Subject: FW: HIGHWAYS ENGLAND RESPONSE (our ref #9246) re. A/122/19/OUT - Land off Arundel Road, Angmering

Planning Application No: A/122/19/OUT

Site: Land off Arundel Road, Angmering, BN16 4ET

Highways England Planning Response (HEPR 16-01)

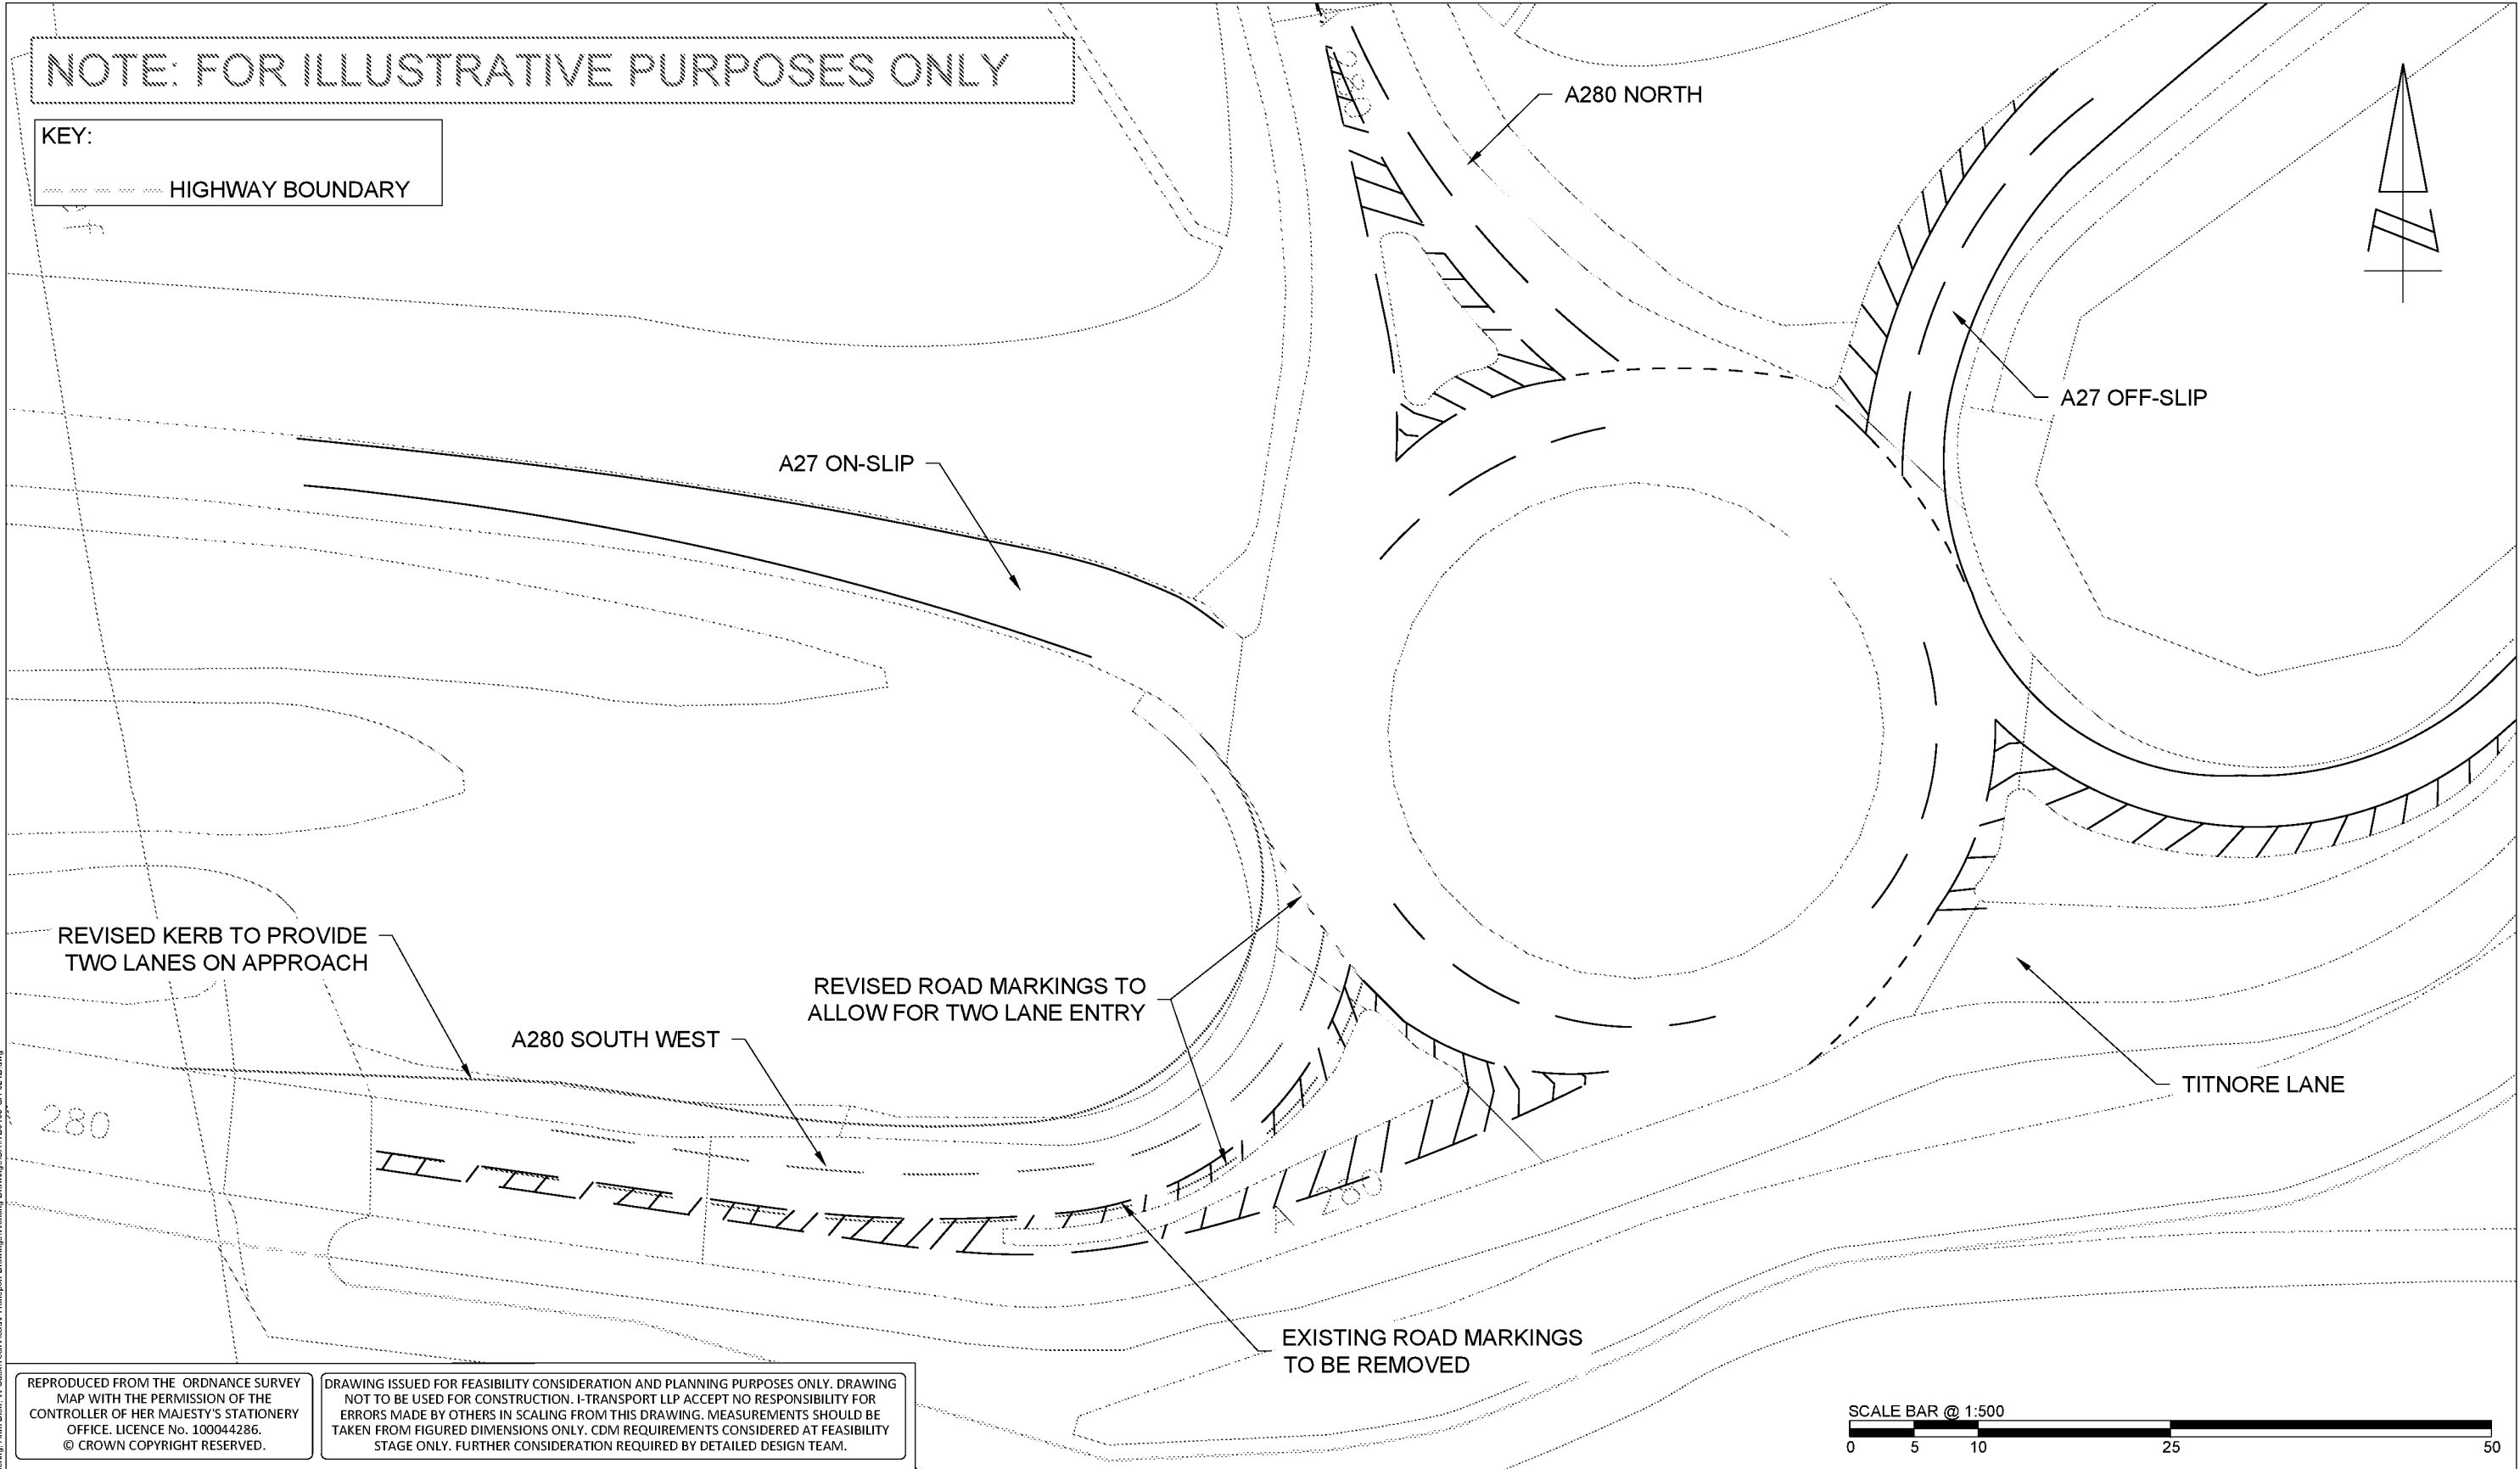
- 2) Prior to the occupation of 80 dwellings within the permitted development, the proposed improvements to the existing pedestrian crossing points on the A27 shall be completed and open to the travelling public as shown on Croft's drawing number "2020-06 – *Proposed Improvements to existing pedestrian crossing points on A27*" (or such other scheme of works substantially to the same effect, as may be approved in writing by the local planning authority (who shall consult with Highways England)), including any necessary transfer of lands to enable the construction and maintenance of the scheme.
